Our ref: DOC20/973295
Senders ref: SSD 10479

Subject: Public exhibition request for comment - 200 Aldington Road (SSD-10479) 200 Aldington Road Industrial Estate (SSD-10479) in the Mamre Road Precinct.

Attachment A – EES comments on 200 Aldington Road Industrial Estate (SSD-10479), Mamre Road Precinct.

Drawing No.	Project No.	Issue
19-609-C1020	19-609	A

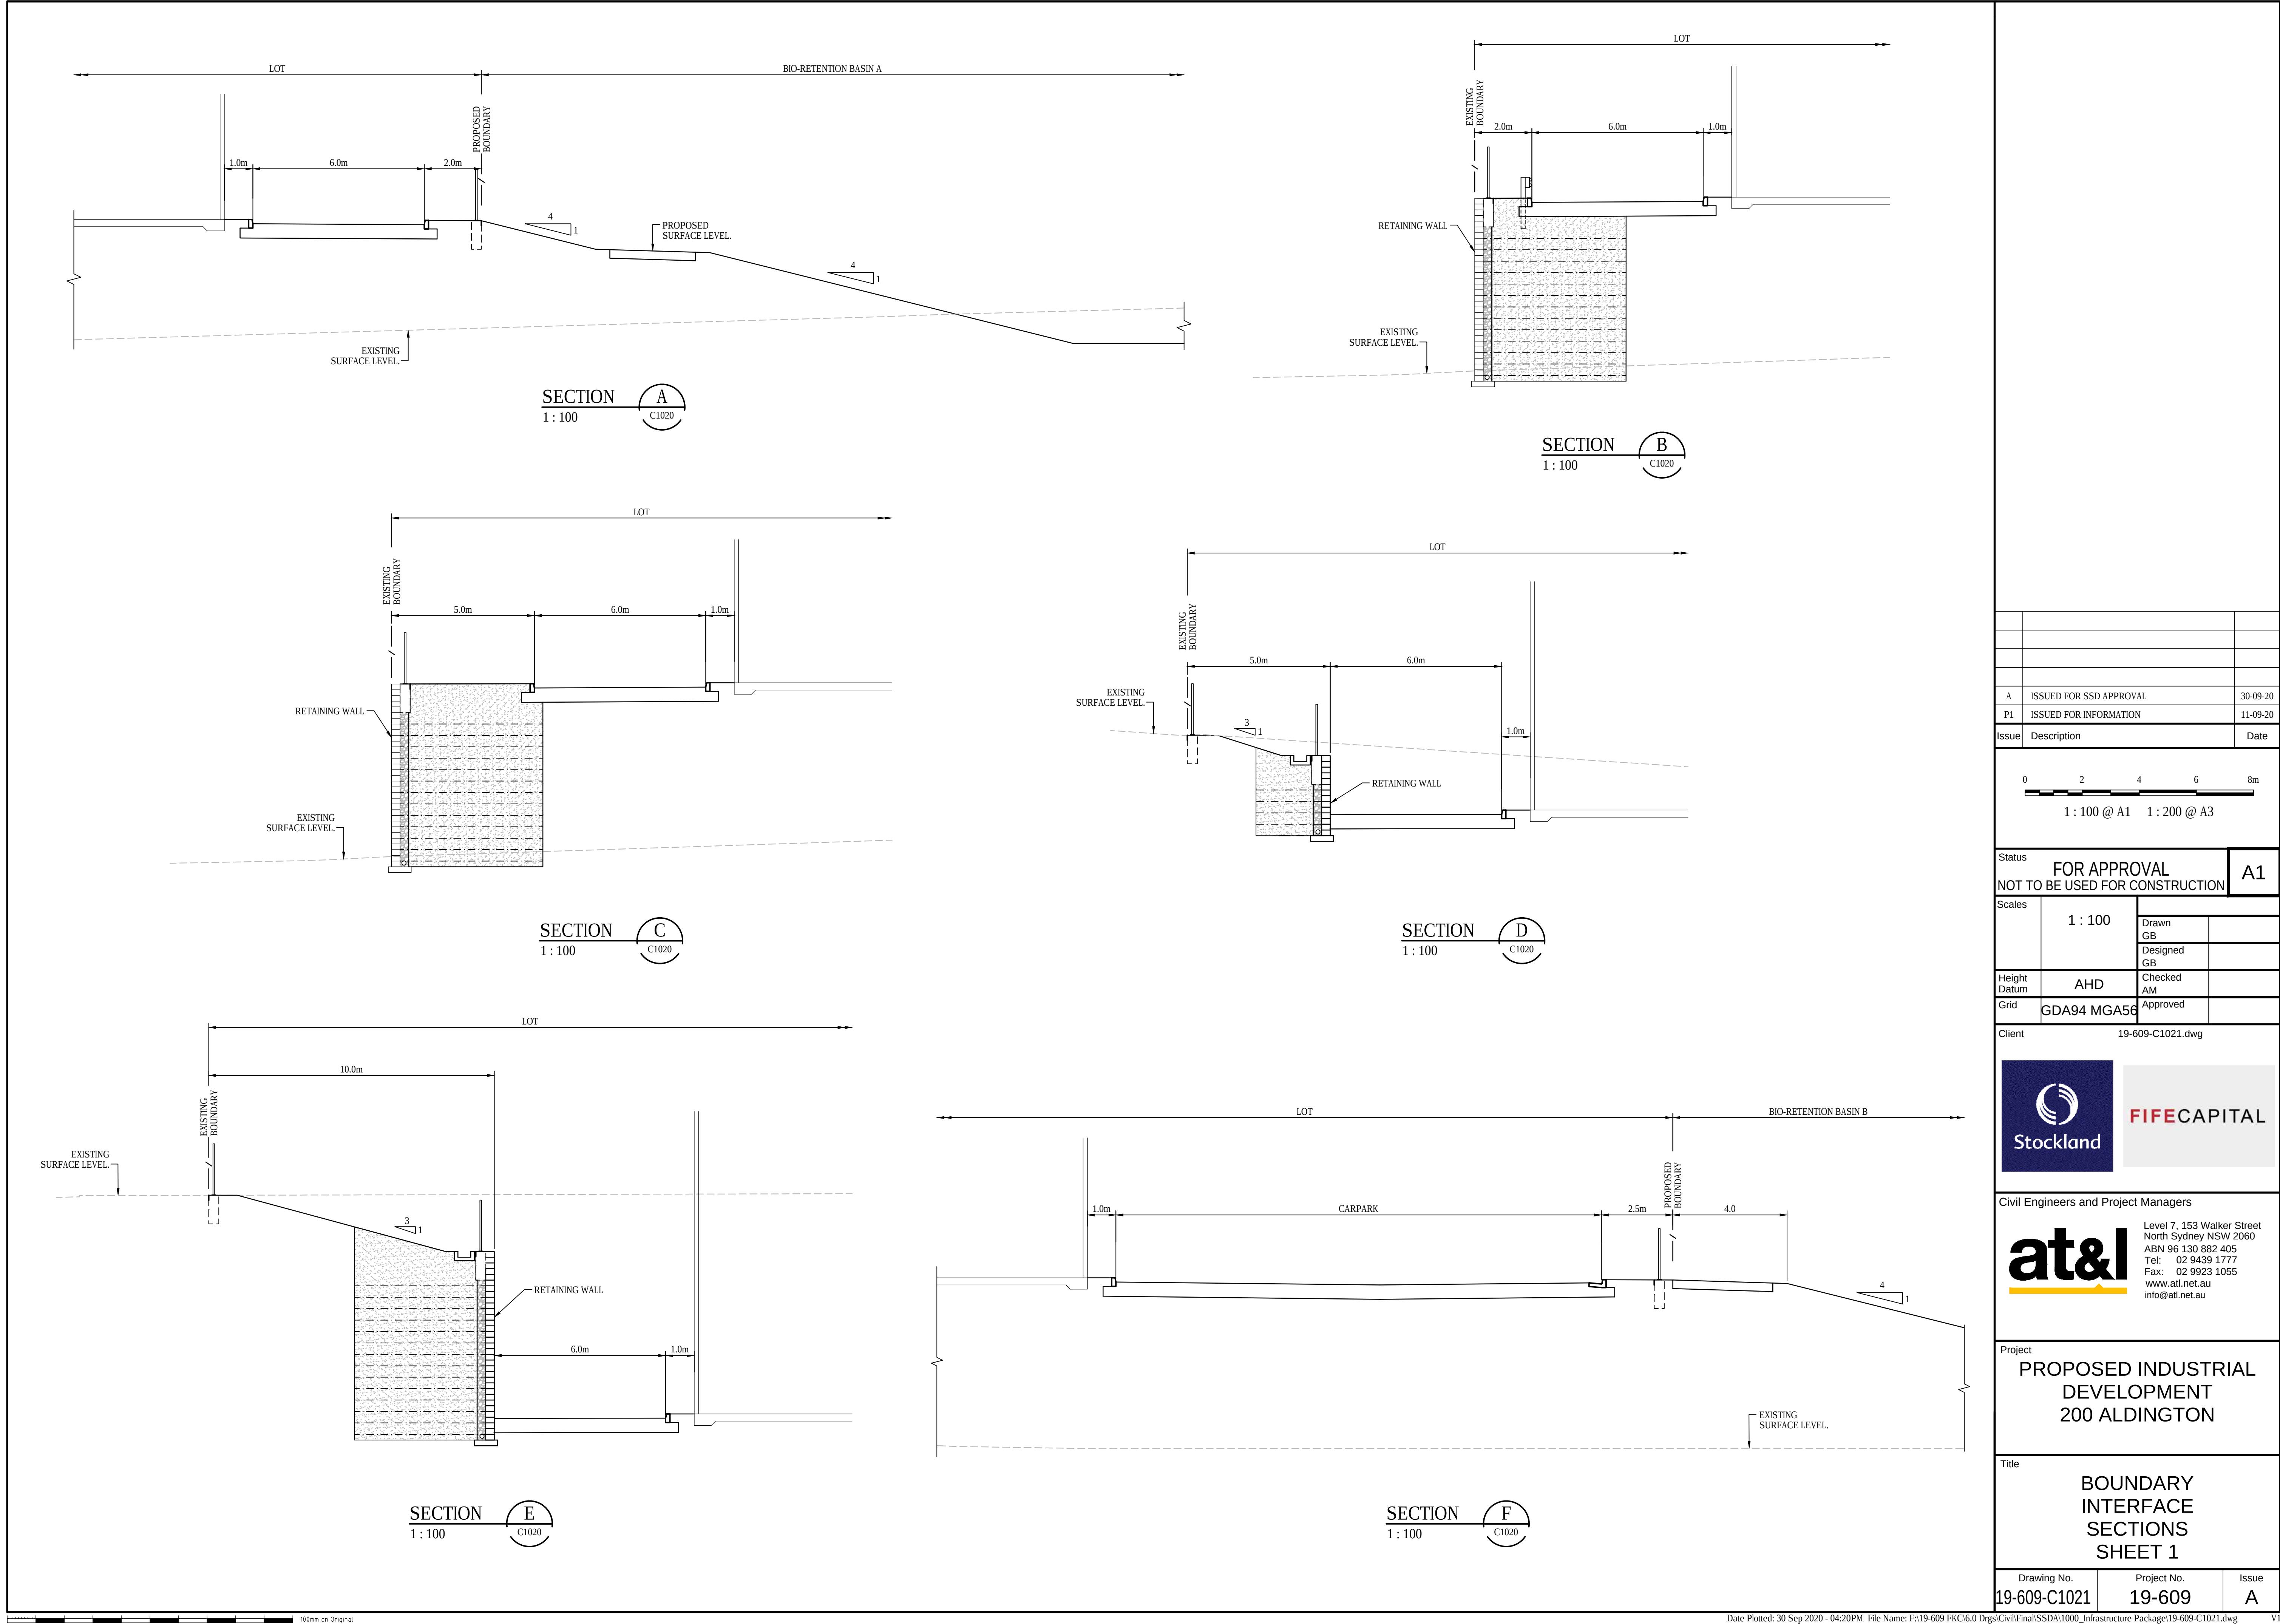
- it is not clear if the 5m construction buffer (as shown in Figure 3 of the BDAR) is compatible with the construction of the retaining walls and bio-retention basin (as shown on drawing no. 19-609-C1020 of the *200 Aldington Kemps Creek 1000-Series Infrastructure Civil Works Package State Significant Development Application* (at&I, 30-09-20)).

Fencing Legend

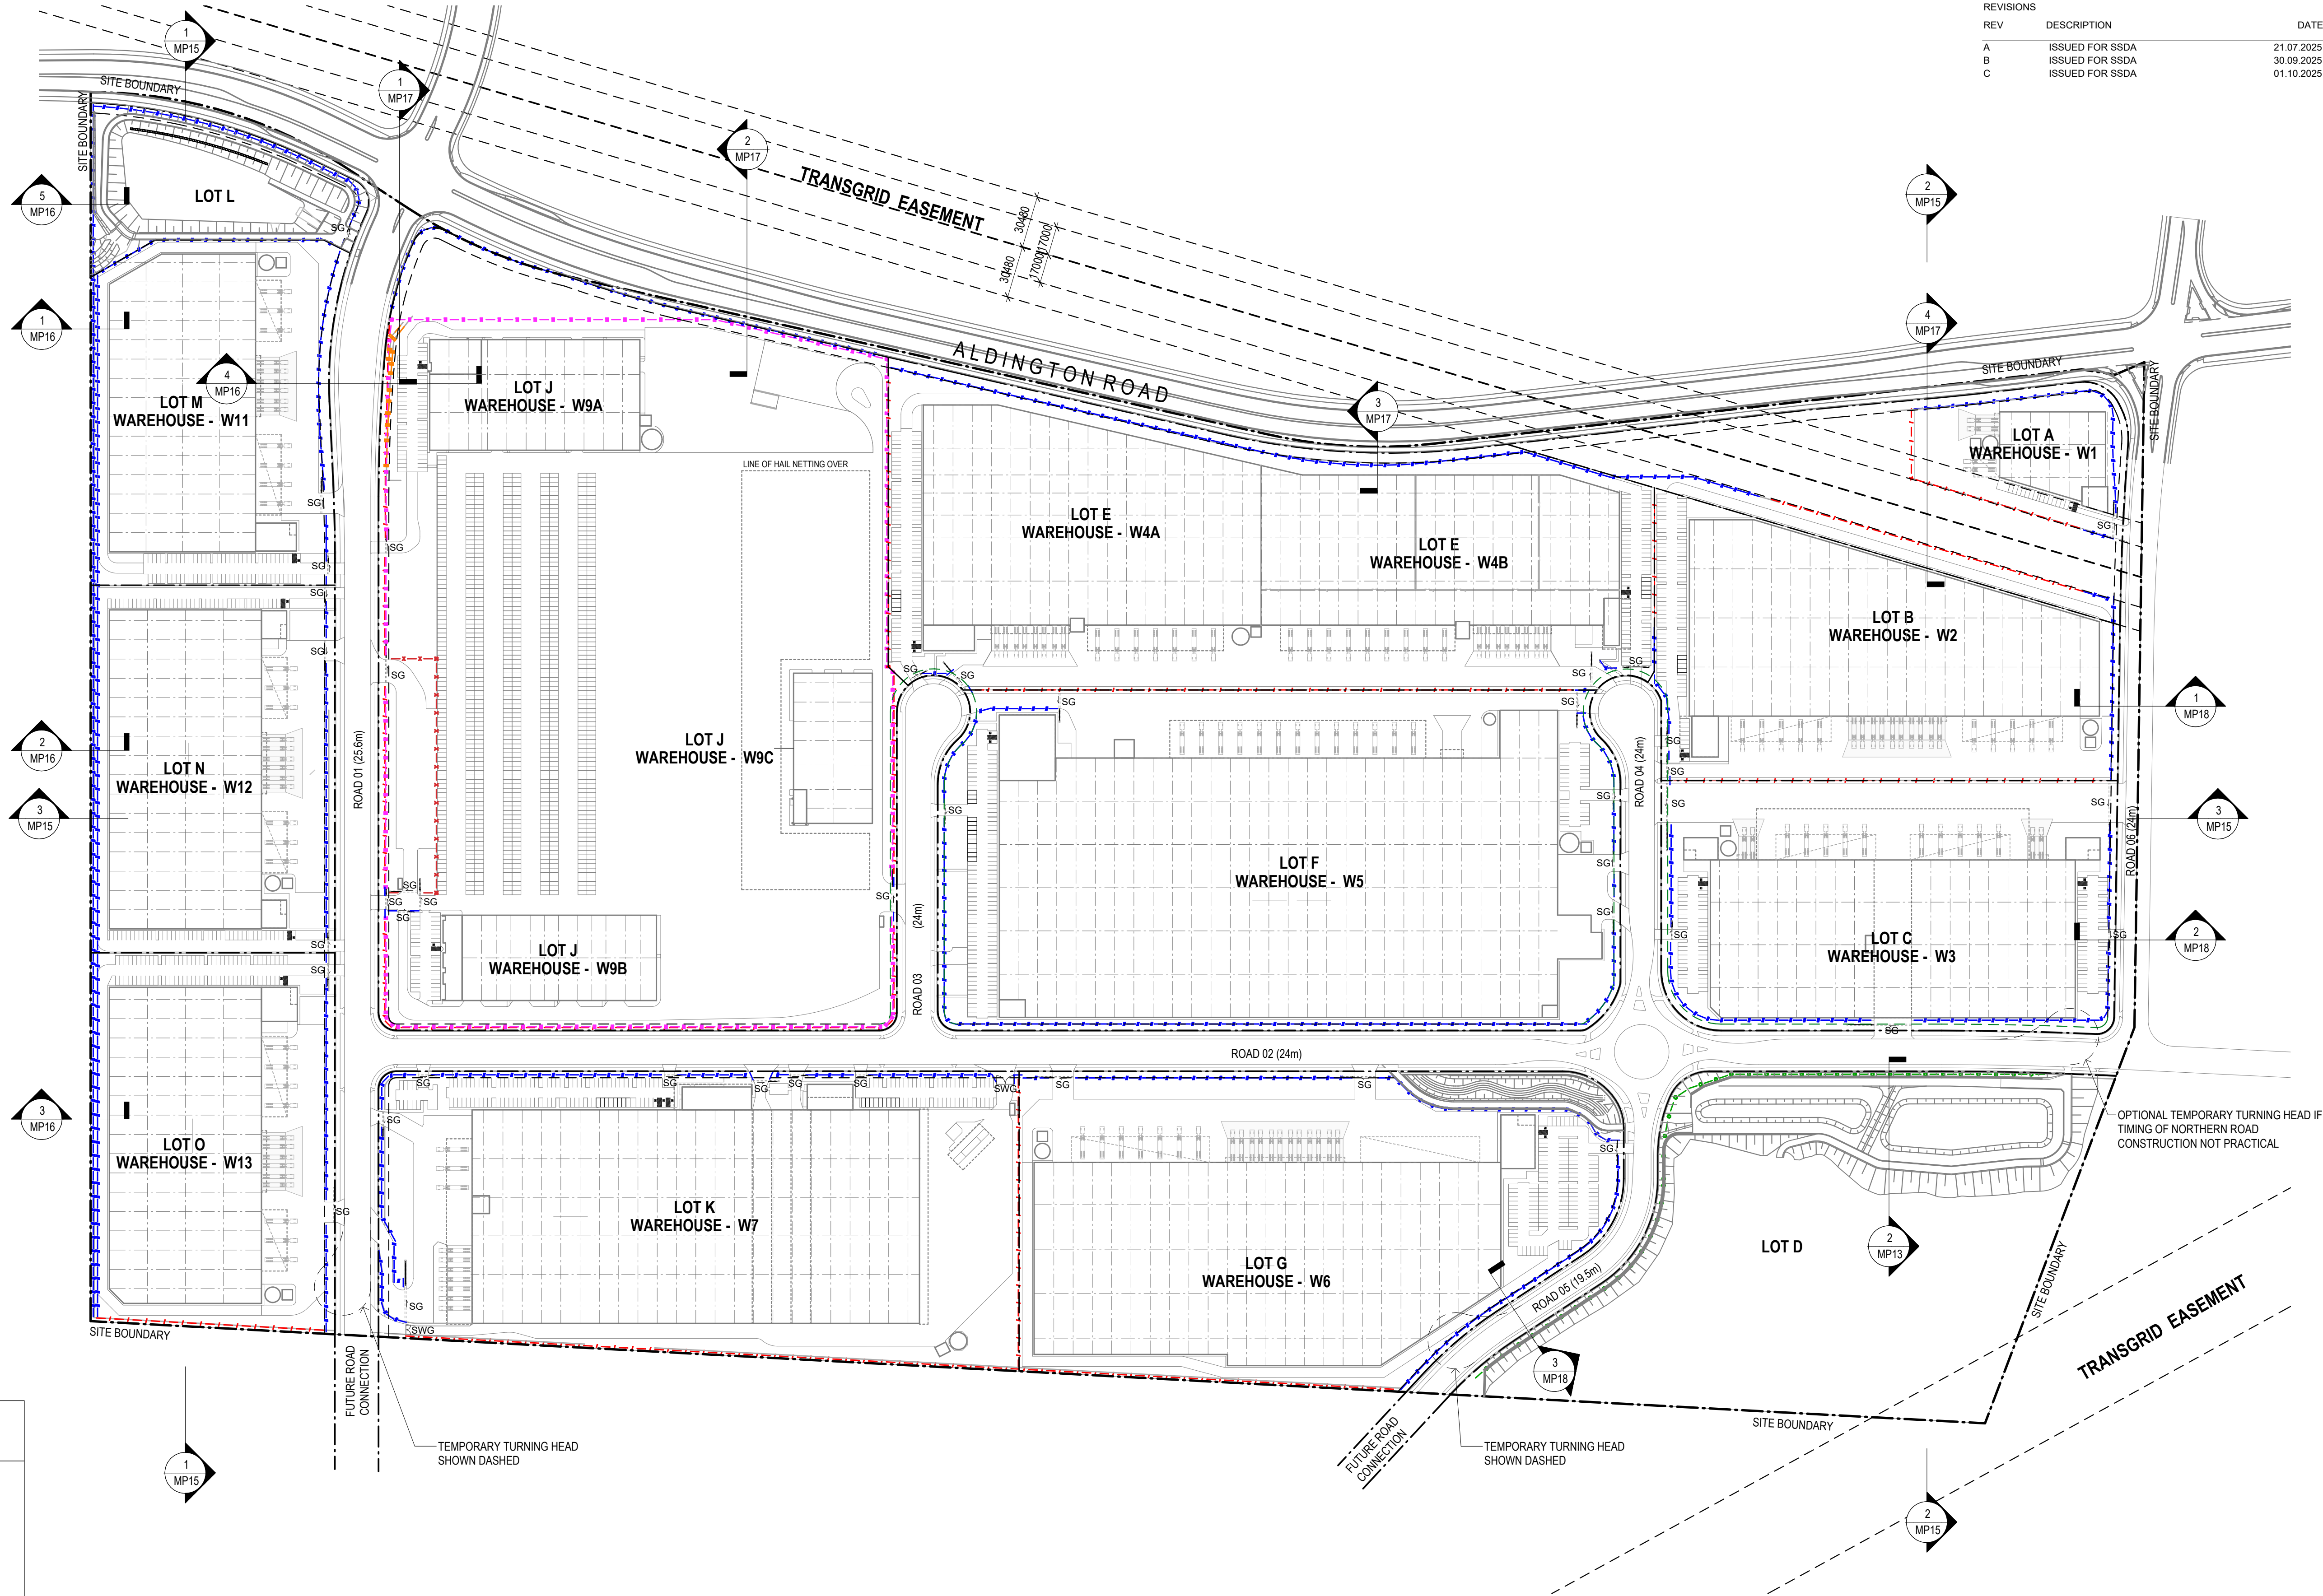
- the *SSDA Estate Masterplan* (drawing no. MP04, date 01/10/2020) and the *Fencing Management Plan* (drawing no. MP11, date 01/10/2020) show several retaining walls on Lot D but it is not clear if these will impact the “unmapped wetland” (as shown in Figure 3 of the BDAR) or PCTs 1232 or 835
